Job No. 192628

May 3, 2024

Re: Response to CGS review comments (dated October 17, 2023) and El Paso County Planning Department comments (not dated)
Meadowlake Industrial, Filing No. 1
Section 9, Township 15 South, Range 65 West
El Paso County, Colorado

PRELIMINARY PLAN

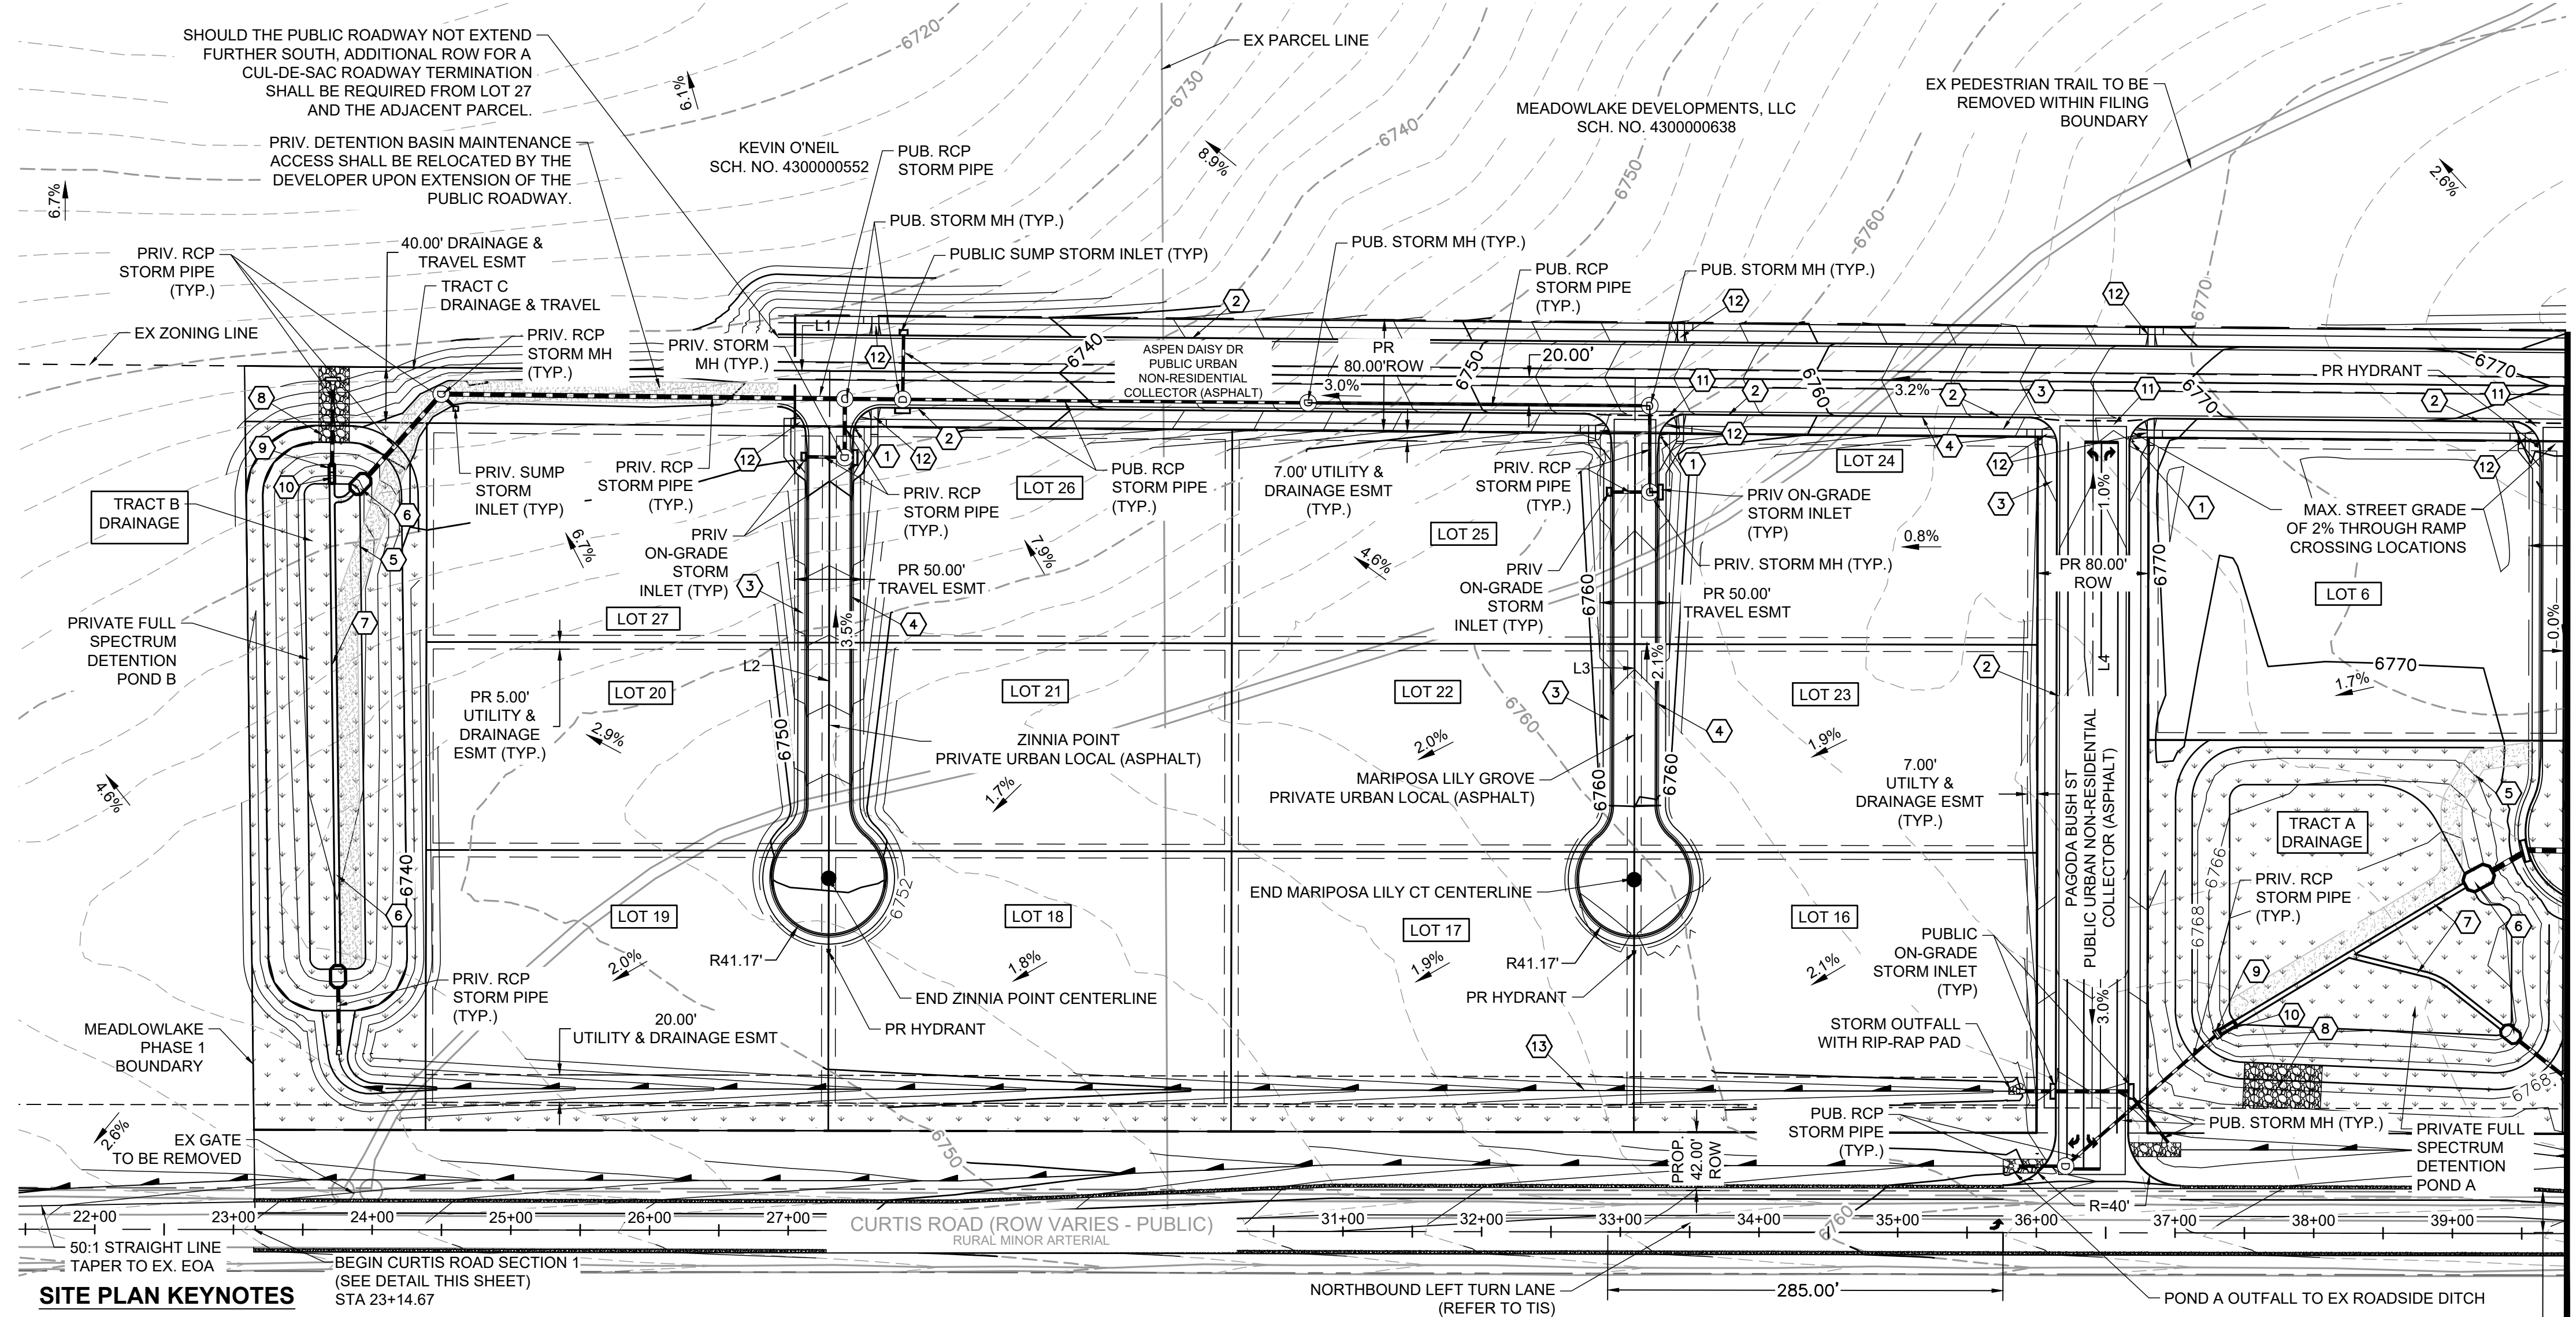
2. A note should be added on the preliminary plans that no inhabitable below-grade or basement areas will be allowed unless shallow groundwater conditions have been addressed with a monitoring program through all four seasons combined with a discussion of regional precipitation trends that can periodically increase the fluctuations expected in groundwater elevations. This evaluation can determine if underdrain systems will be needed and if they can be placed during the planned over-excavation for swelling and compressible soils and bedrock.

4. The Geologic Hazard Note on the preliminary plan (HR Green, August 25, 2023) should also include expansive and compressible soils as geologic conditions present at the site.

A note has been added to the preliminary plans that no inhabitable below-grade basement areas will be allowed unless a year-long ground water monitoring program has been completed.

It is our understanding the Geologic Hazard Note has been updated.
